Consultation Response from: KC Environmental Health (Pollution & Noise Control)
2022/93154 Land at, Penistone Road, Fenay Bridge, Huddersfield, HD8 0AW
Erection of 68 dwellings with associated access, parking, open space, landscaping and infrastructure works (including installation of surface water attenuation tank)

Date Responded: 05 December 2022	Responding Officer: RM NH MN	Responding Ref: WK/202237898
---	---	---

Figure A3: Daytime predicted façade noise levels

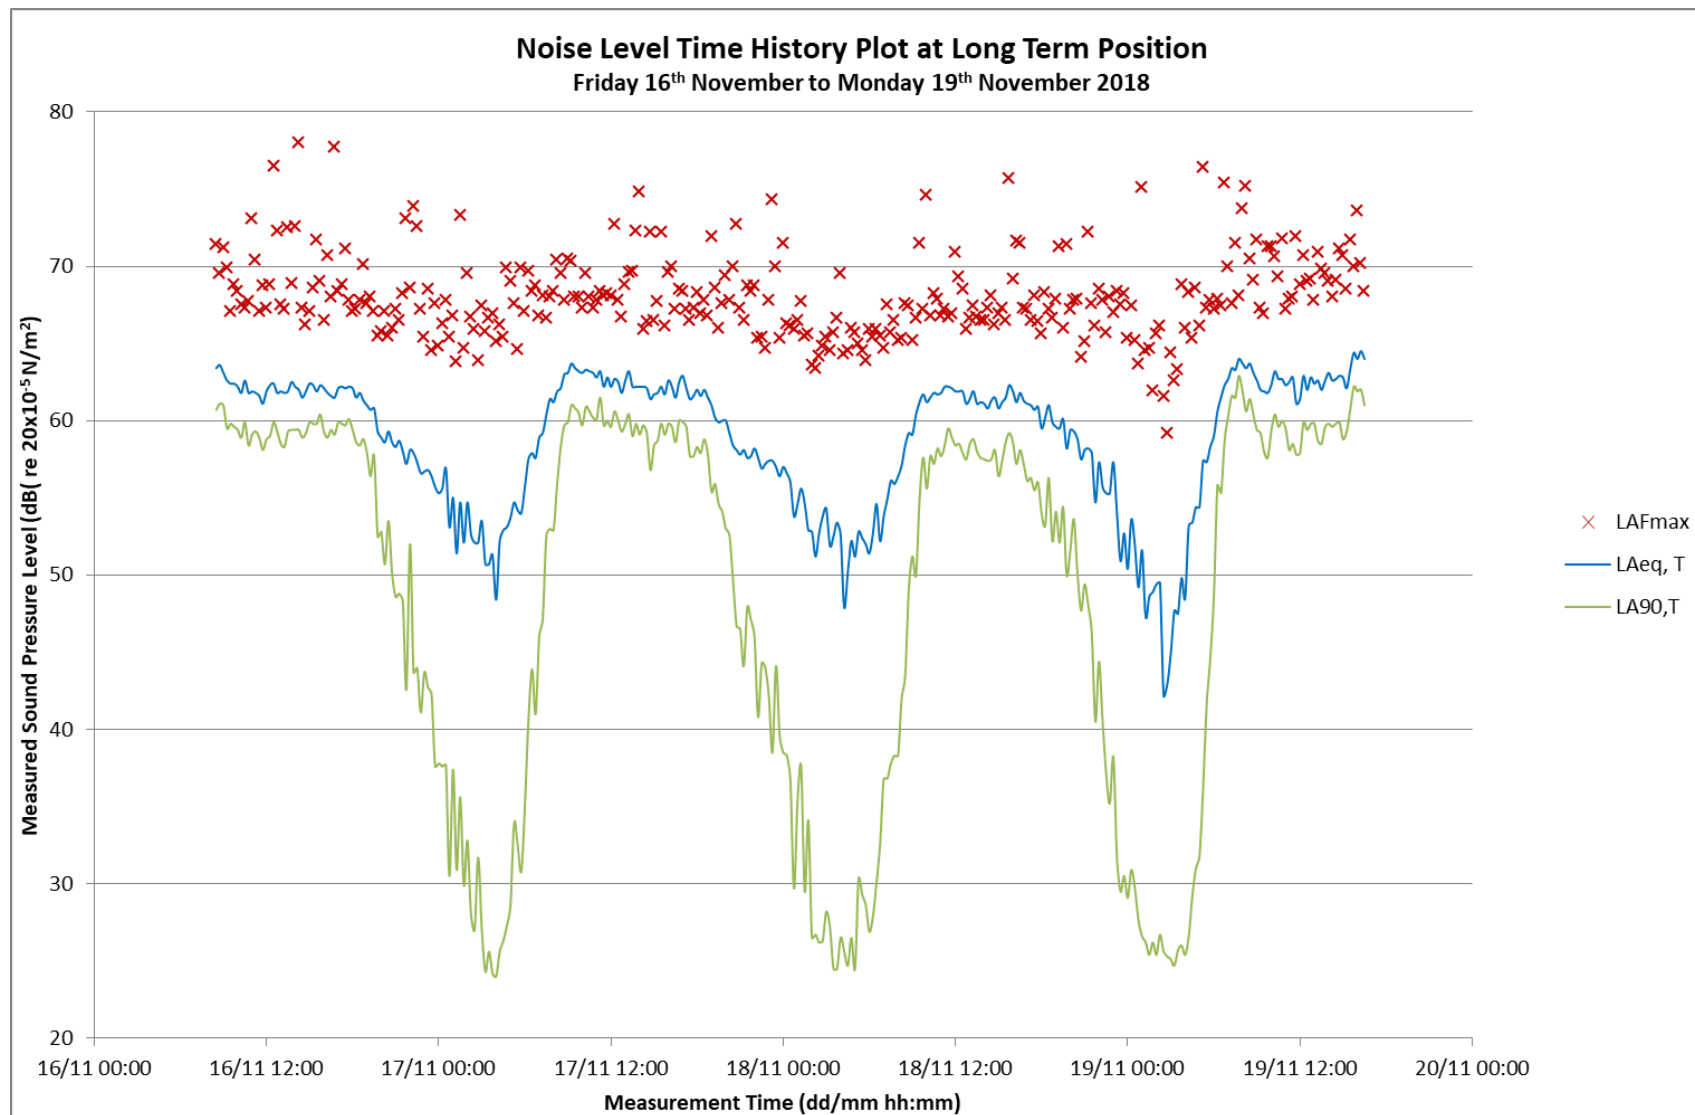
Based upon the measured figures, noise modelling has been conducted and table 5 shows a colour coded level of façade attenuation with appropriate ventilators required to ensure internal levels meet with the requirements of BS8233 for both daytime and night time.

There is some uncertainty within the report on the site layout, the ventilation strategy and the fixed mechanical plant. We also have concerns about the high levels within the external amenity space. A condition is recommended for a further/addendum report to be submitted addressing these uncertainties and consideration of a higher specification acoustic barrier.

- Identify which rooms of which plots referenced back to the approved Noise Assessment require a ventilation system

- The acoustic specification of the proposed ventilation system demonstrating that when operated it will not cause indoor noise target levels to be exceeded
- The ventilation scheme must demonstrate that the air intake is located away from the sources of noise and/or poor air quality.

Figure 4 – Proposed Development modelled receptor locations

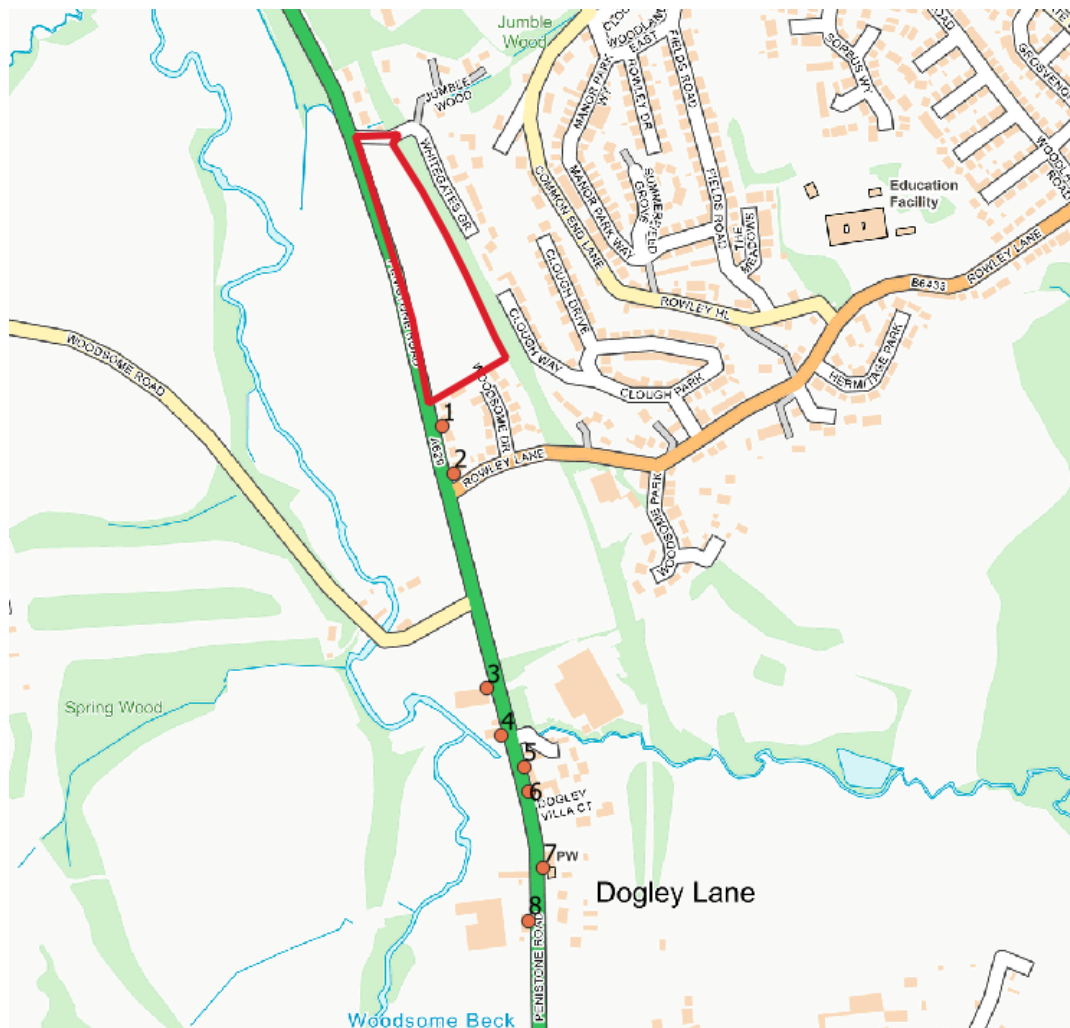
- There is no mention in the report of other local plan developments within the area, and it is unclear if the future traffic data includes other committed developments and the cumulative impact this will have on air quality. This requires clarification.
- No plan has been provided showing the location of the 8 existing receptors in relation to the development site.
- The best practice mitigation measures that are recommended for the construction phase, are to be incorporated into a Construction Environmental Management Plan (CEMP) in the form of a site-specific Dust Management Plan.

- Include the impact on air quality of other committed developments in the area.
- Include a plan showing the location of the 8 existing sensitive receptors in relation to the development site.
